Your ref:  
Our ref: 22/01973/F  
Please ask for: Luke Swales  
Direct dial: 01553 616865  
E-mail: borough.planning@west-norfolk.gov.uk

Details: **Construction of carport and storage shed at 50 Common Lane North Runcton King's Lynn Norfolk PE33 0RE**

Block Plan

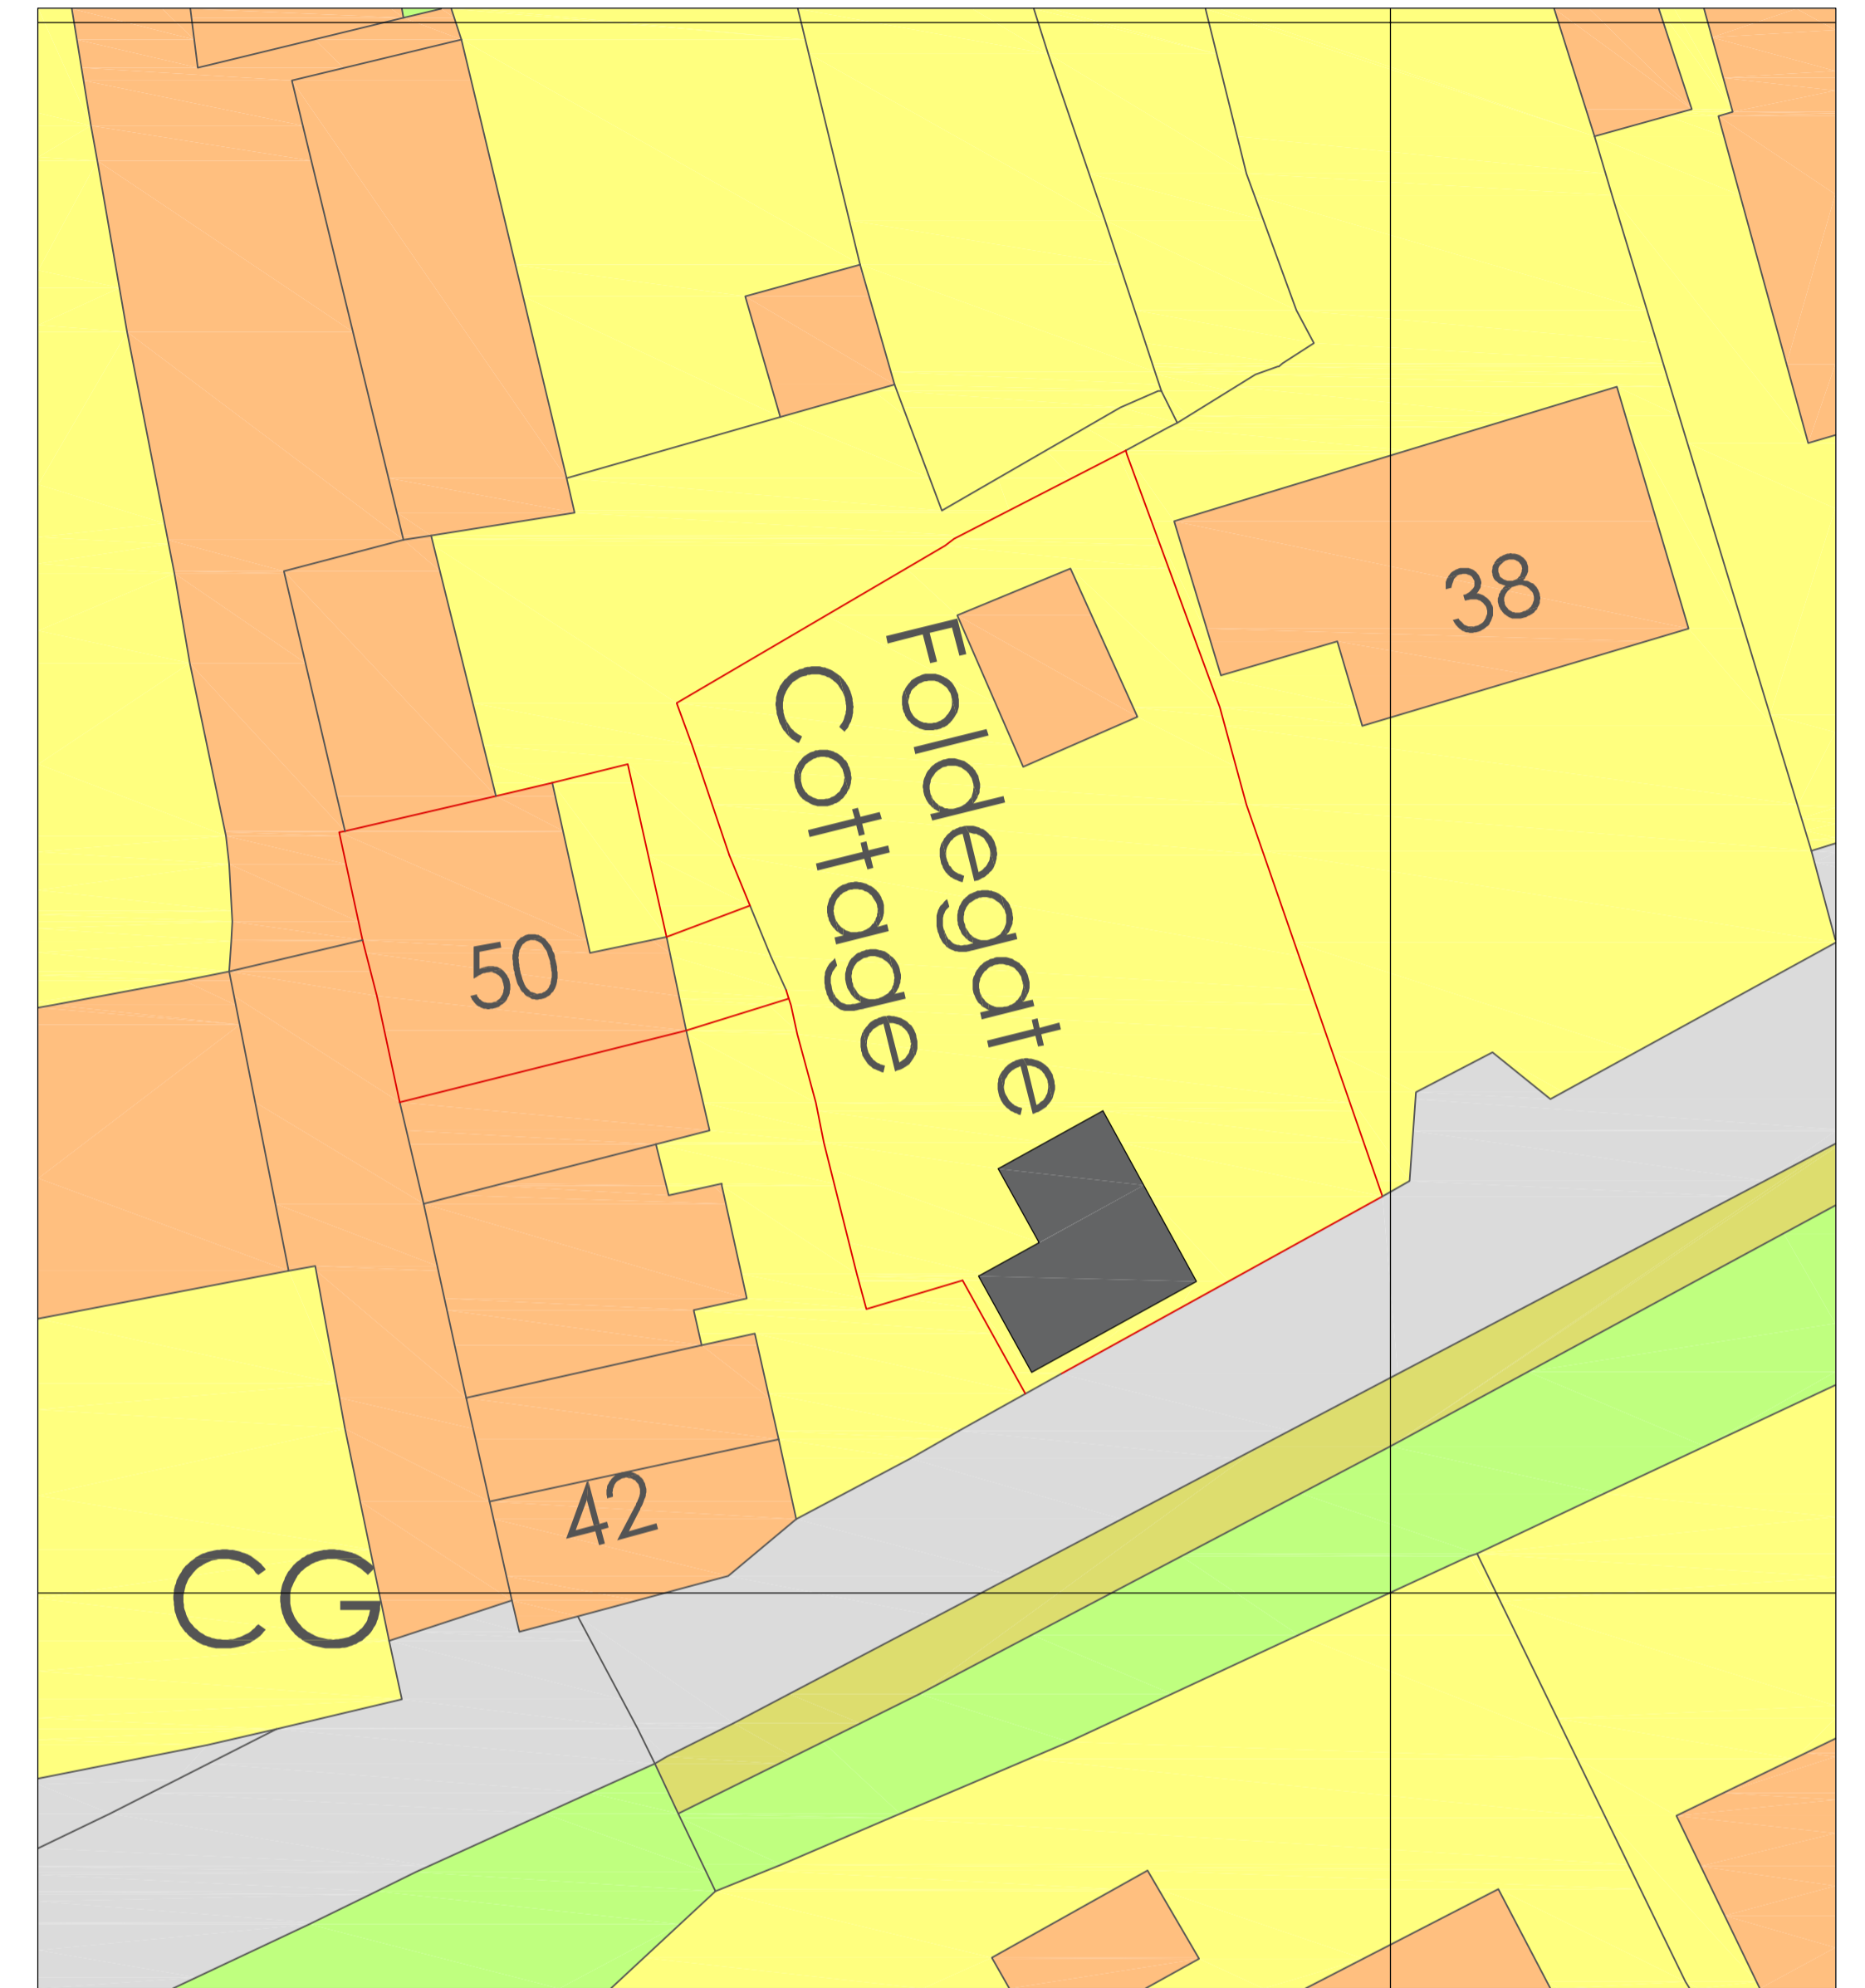
1. It appears that the proposed works have not been shown on the submitted block plan. Please add the proposed works to the block plan and resubmit
